TR010063 Factors to be considered as to how the application should be dealt with by the ExA from ref.no: 20047638.

Your REF: TR010063
IP REF: 20047638

WEST CHELTENHAM, Joint Core Strategy Strategic Allocations A11

Original Size: A1	Scale: 1:1250	Project Ref. No: 5228847	Sheet: 5 of 16	Rev: C02
-------------------	---------------	--------------------------	----------------	----------

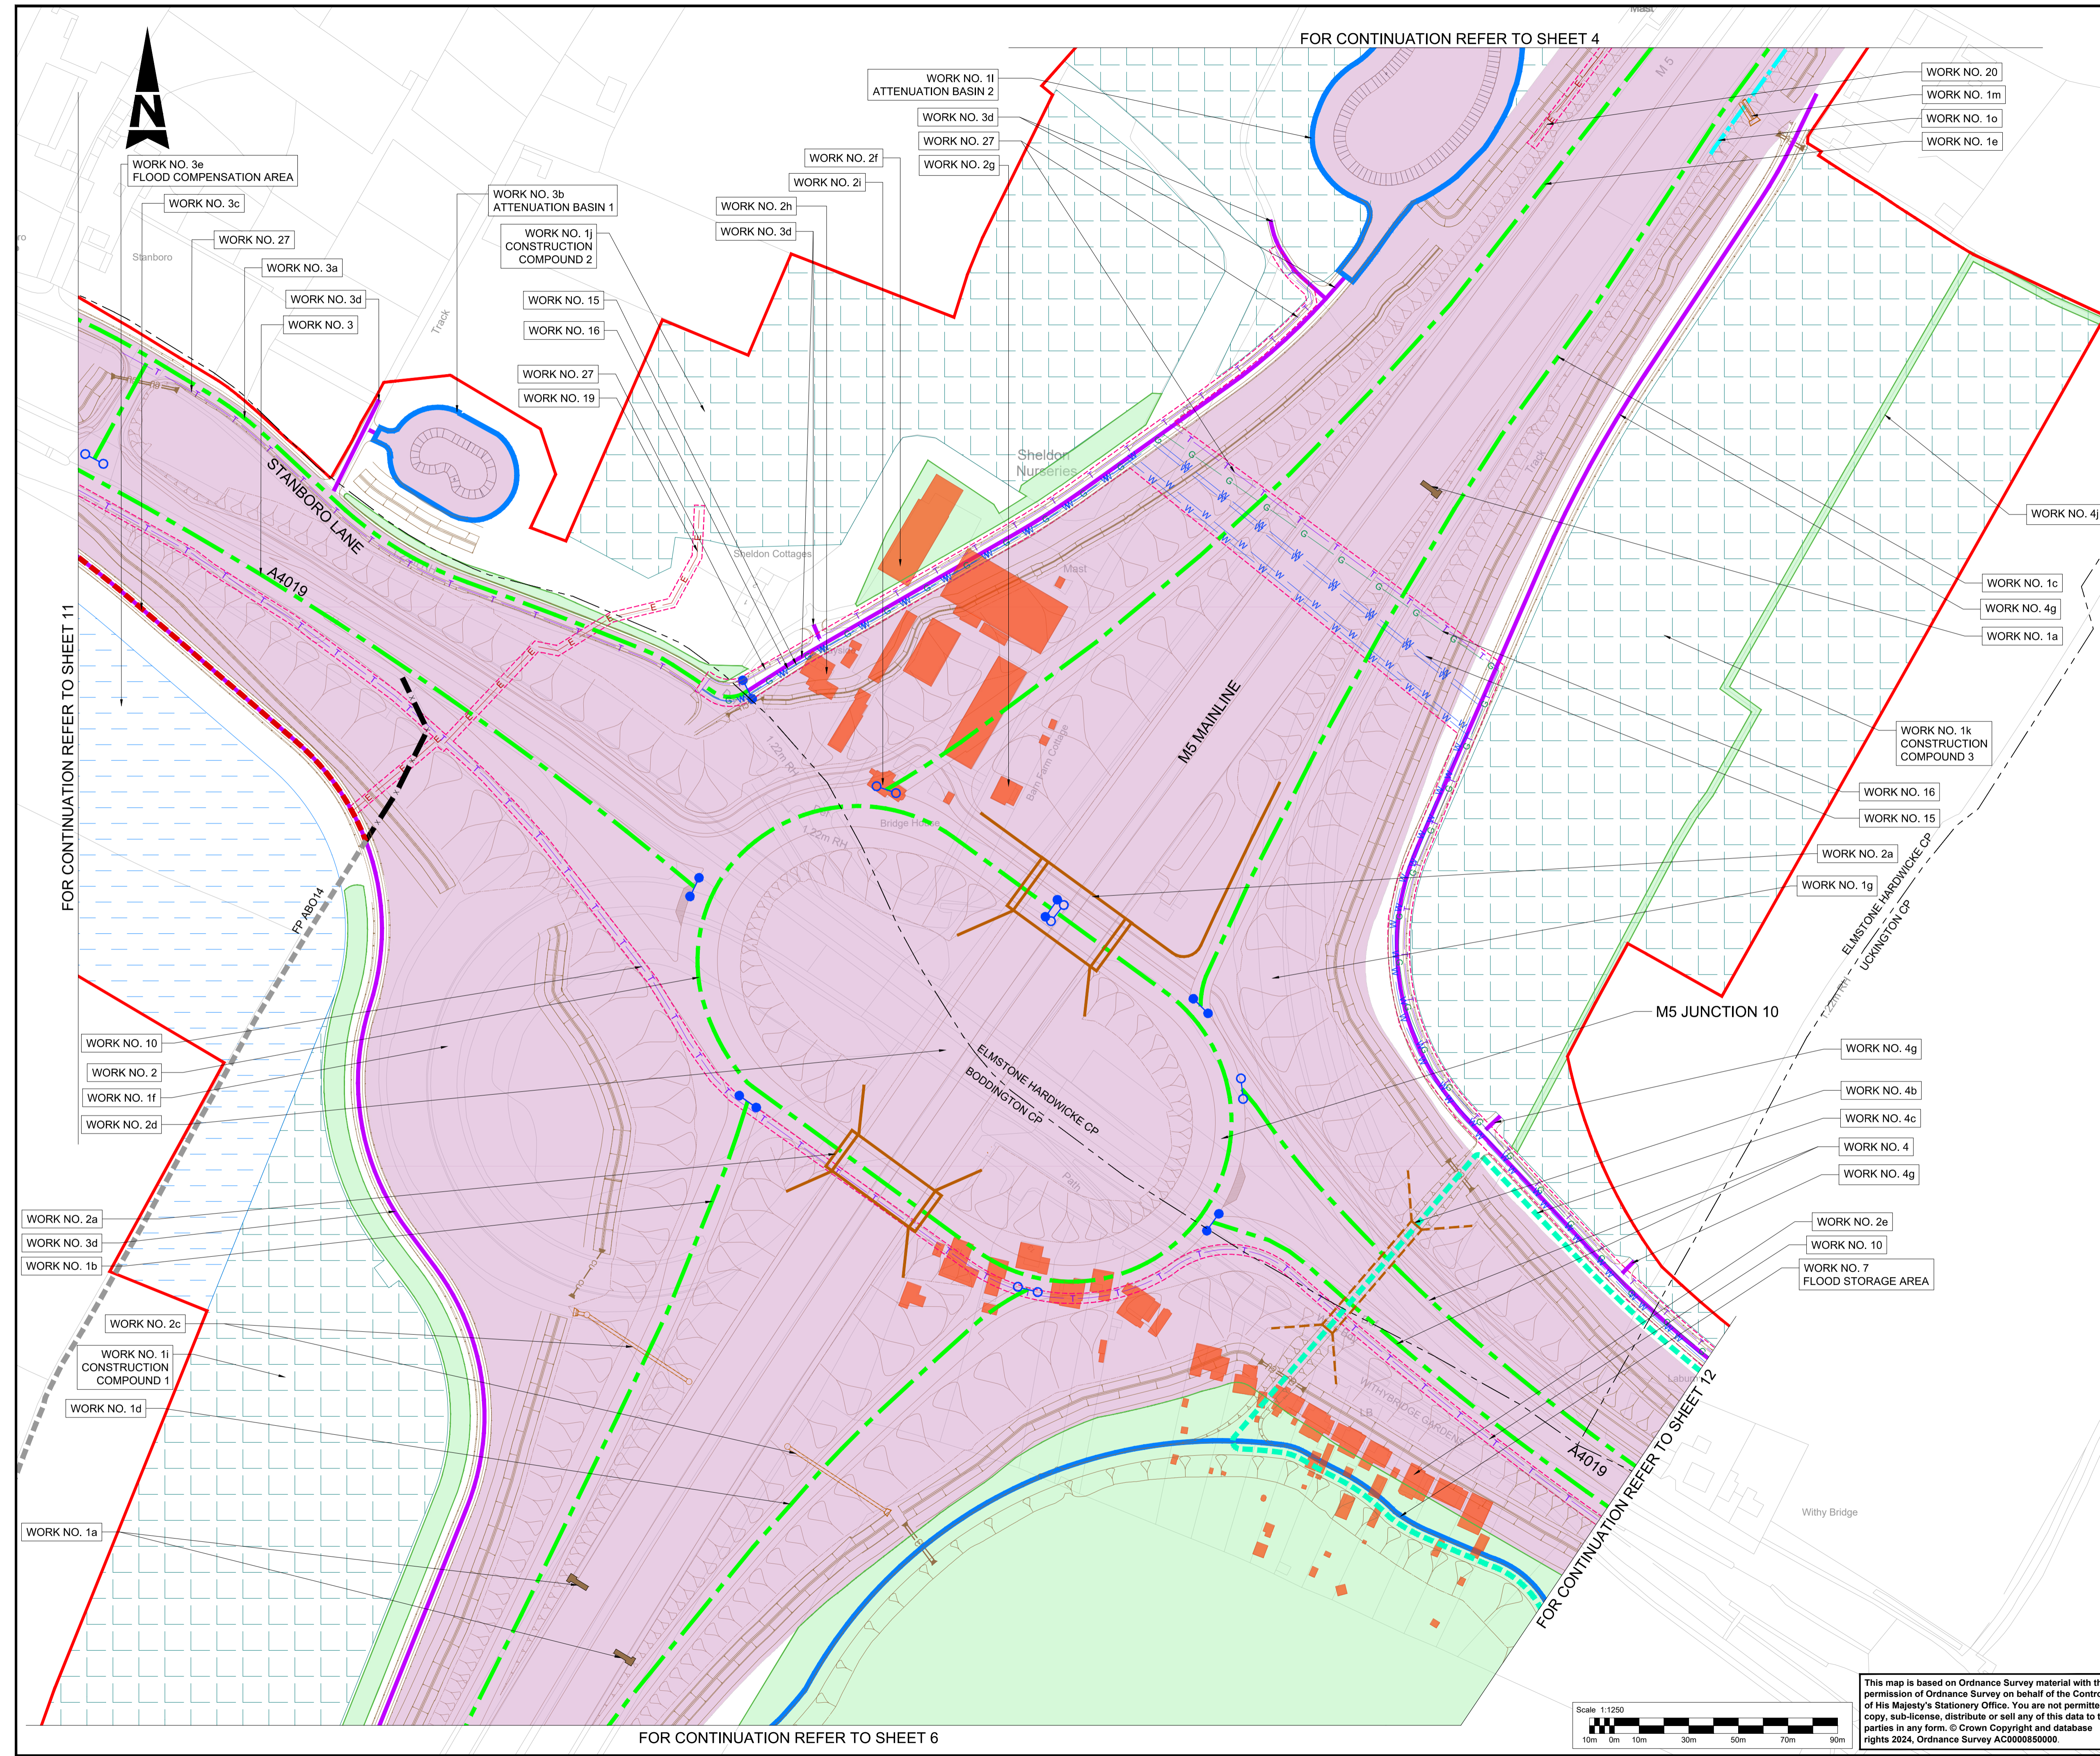
- 7) Presently drawings show two new culverts under the B4634 and this will make three with the additional one towards the House in the Tree pub. In my opinion this is not enough for such a huge development area as presently there are two already in situ, one towards the House in the Tree and a smaller one around the north east corner of my field that presumably goes under the B4634.
